Eastergate Parish Council
Mr GR Sleet
9 Hedgeway
Bognor Regis
West Sussex
PO22 7QY

Your Ref: OWPC15800
Our Ref: EG/69/17/PL
Please ask for:
Mr S Davis

4 No. live/work units, Research & Development propagation building & growing area, garden room, fuel store & greenhouse to main dwelling & formation of new access. This application is a Departure from the Development Plan.
Swallowfield Eastergate Lane Eastergate

Thank you for your internet comments made on 11th October 2017 which has been recorded as **'an objection'** with the comments as follows:

Heather Godmark			
Swallowfield, Eastergate Lane			
Visibility Splays and Swept Path Analysis			
Varies @ A2	SMO	ALB	PMR
October 2017	2016/3448/001		C

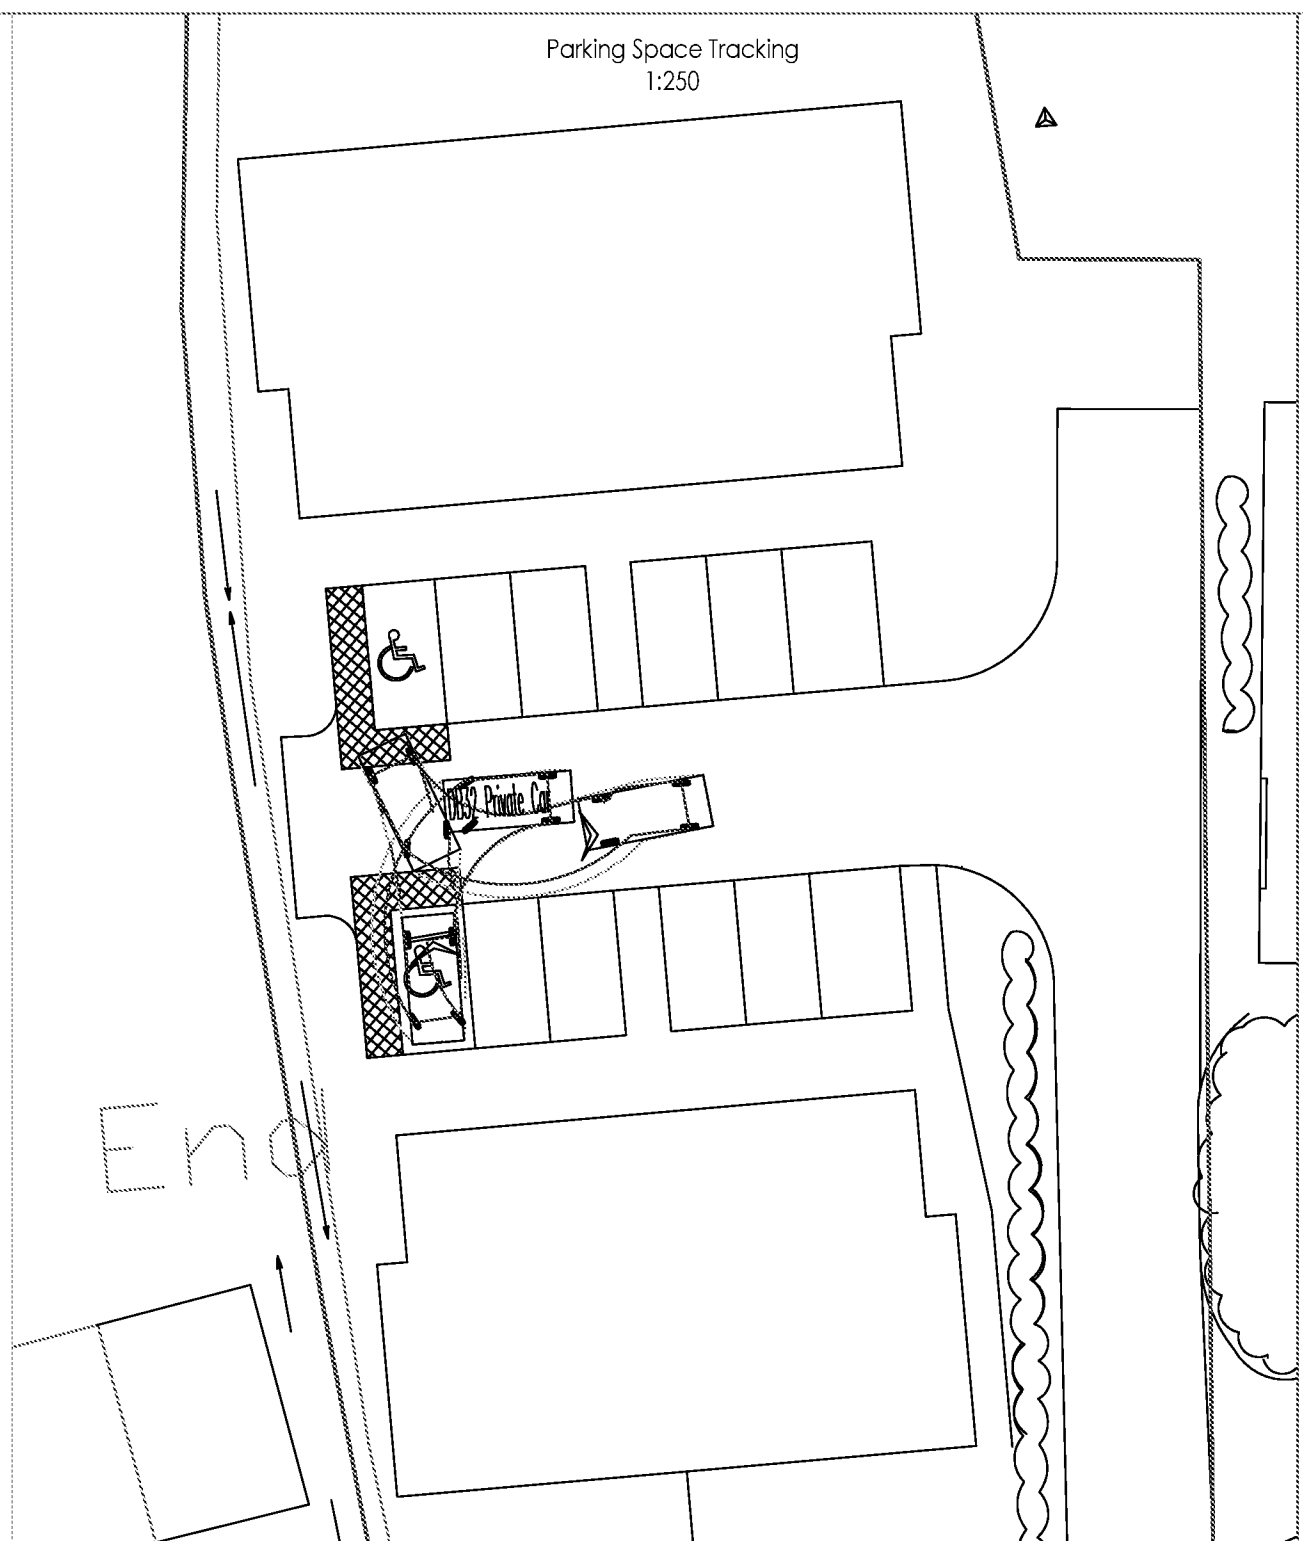
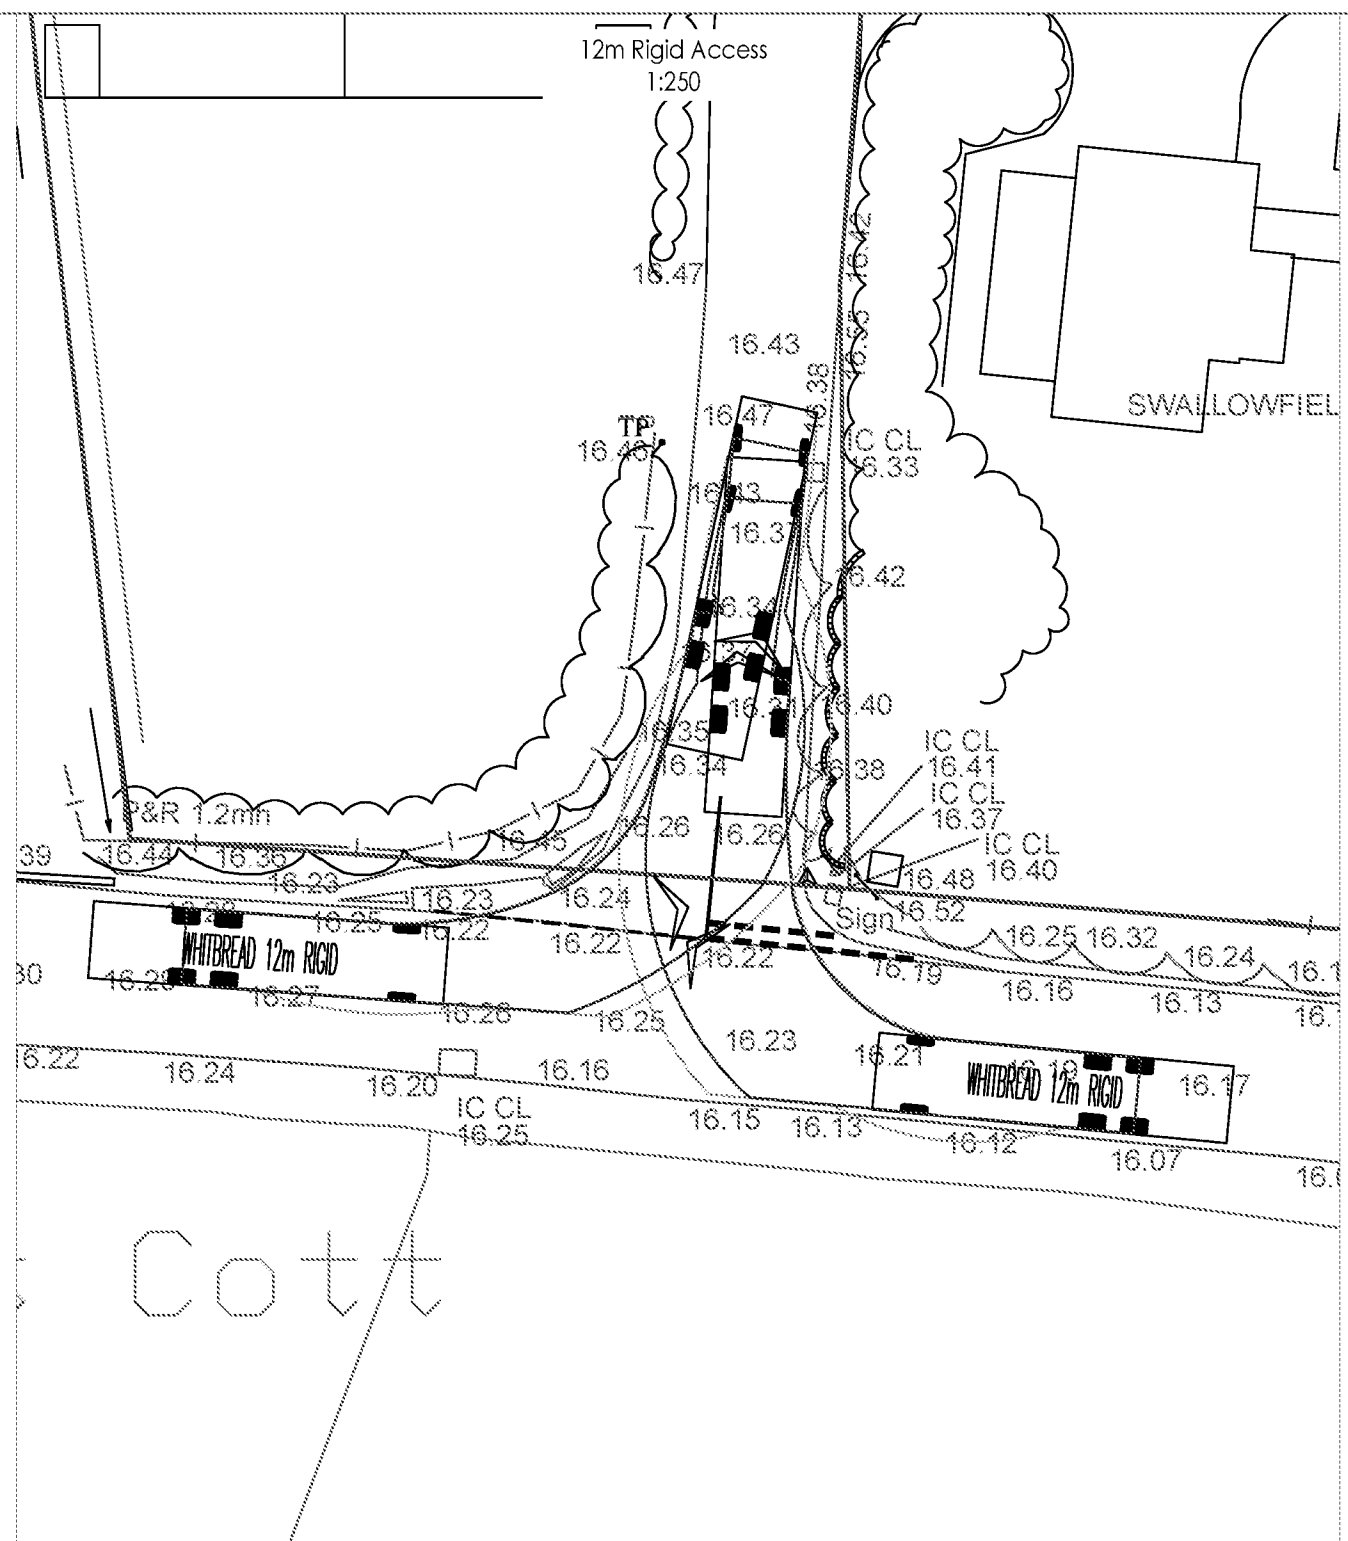
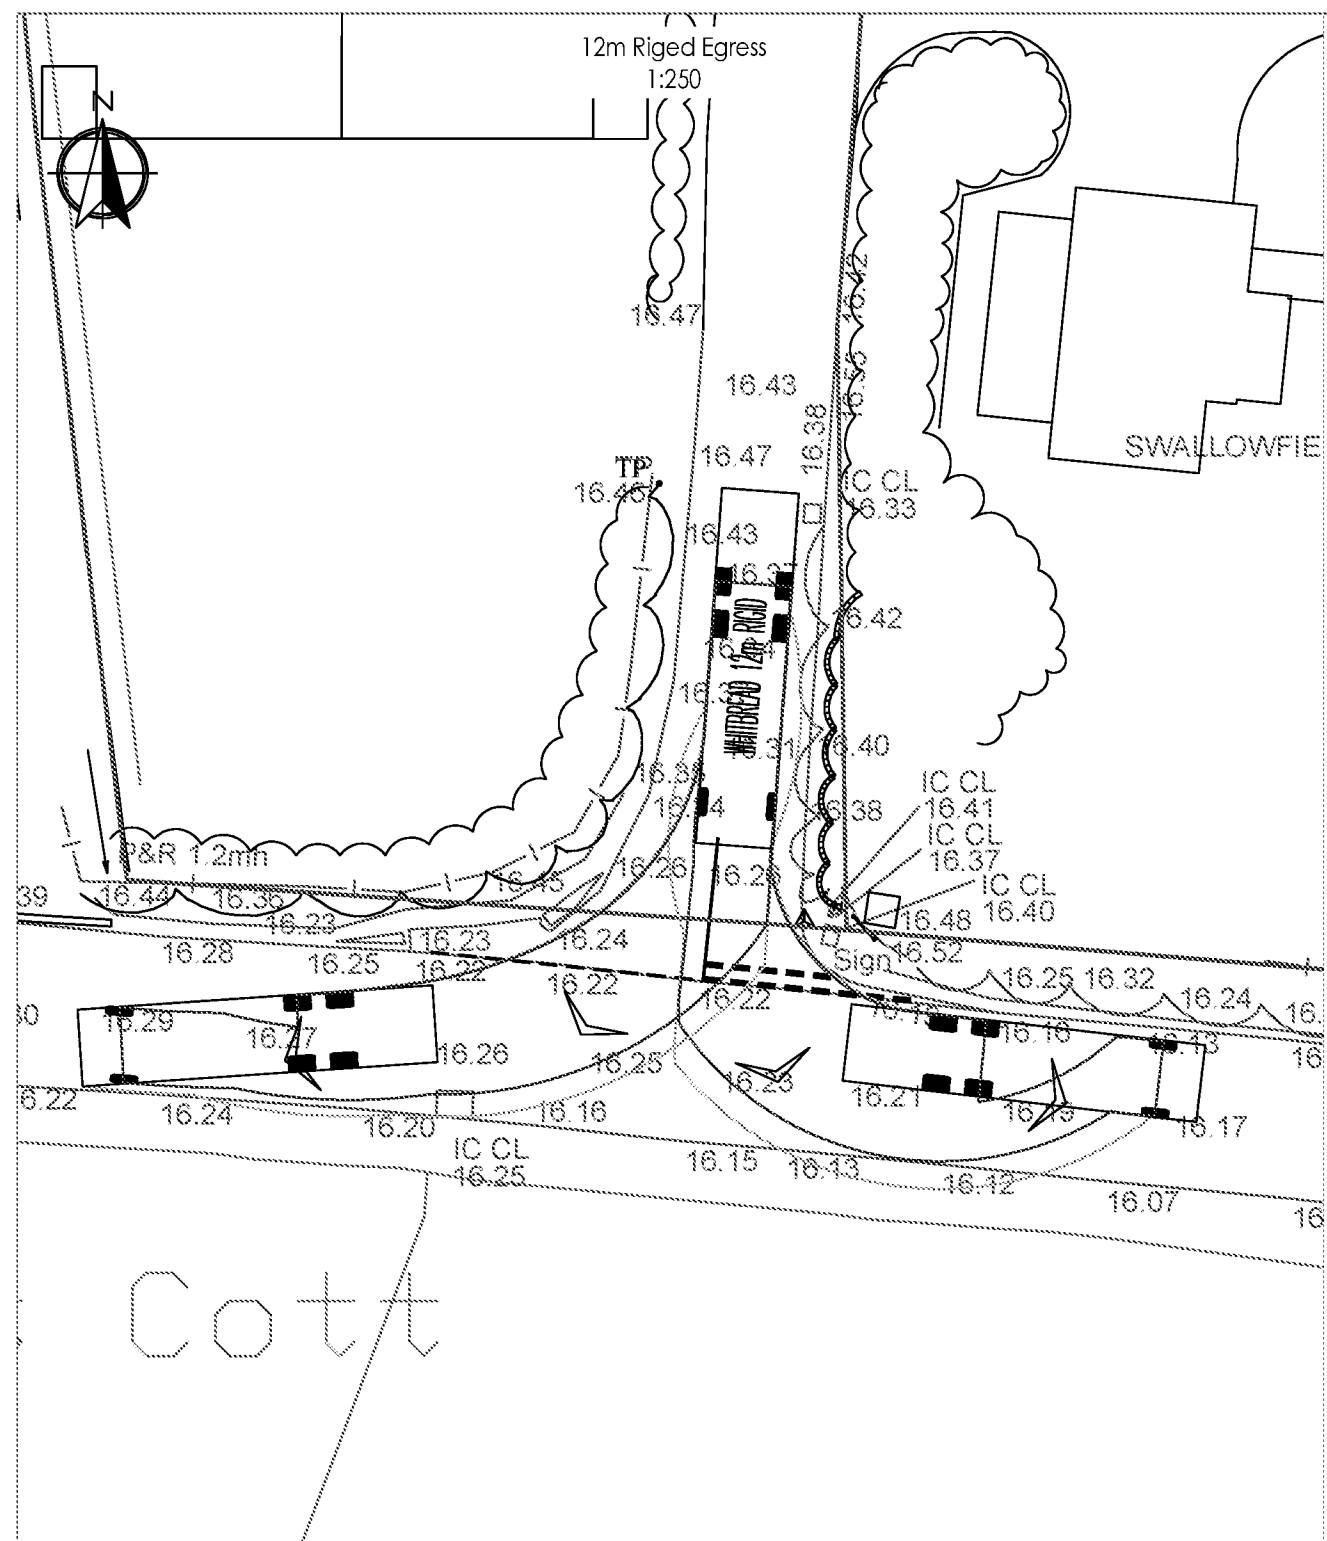
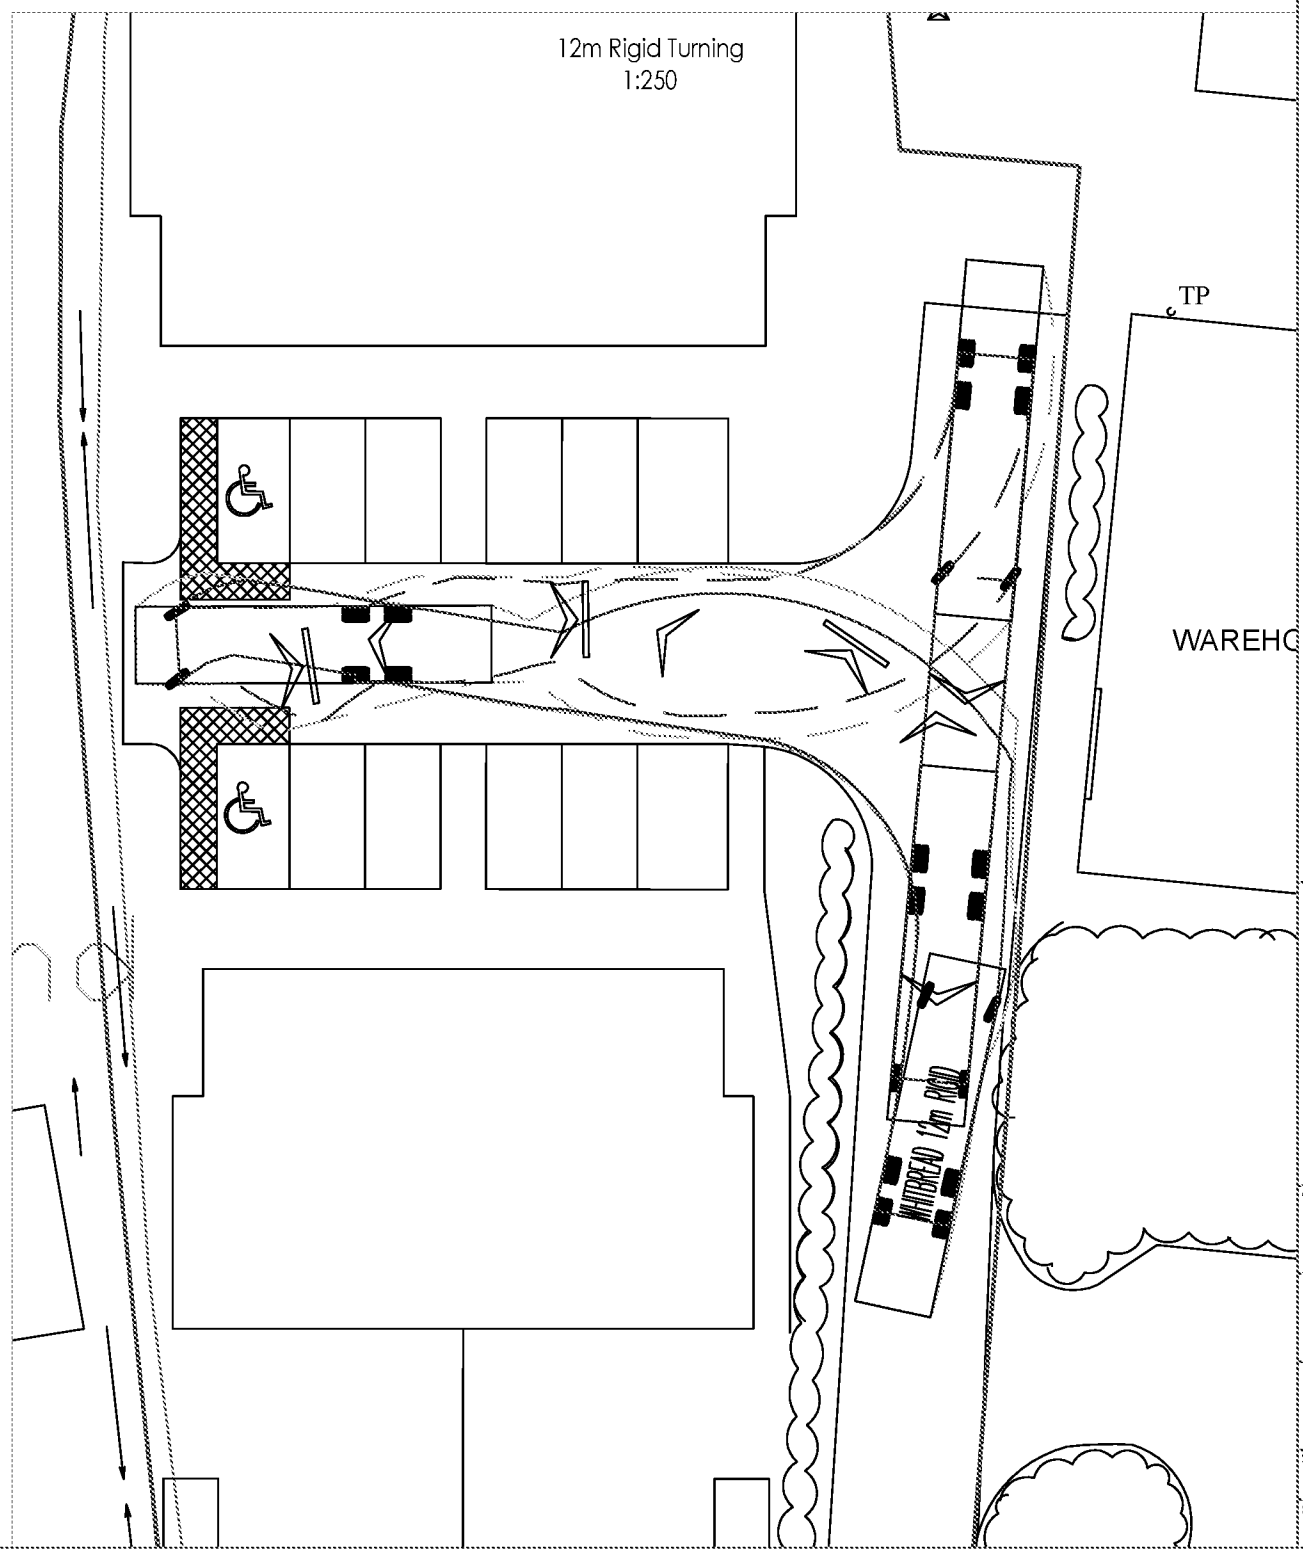
The council considers that the application should not be permitted without an allocation of space, on site, for articulated and other vehicles to turn. A condition requiring the use of such turning space should, if possible, be added to any permission.
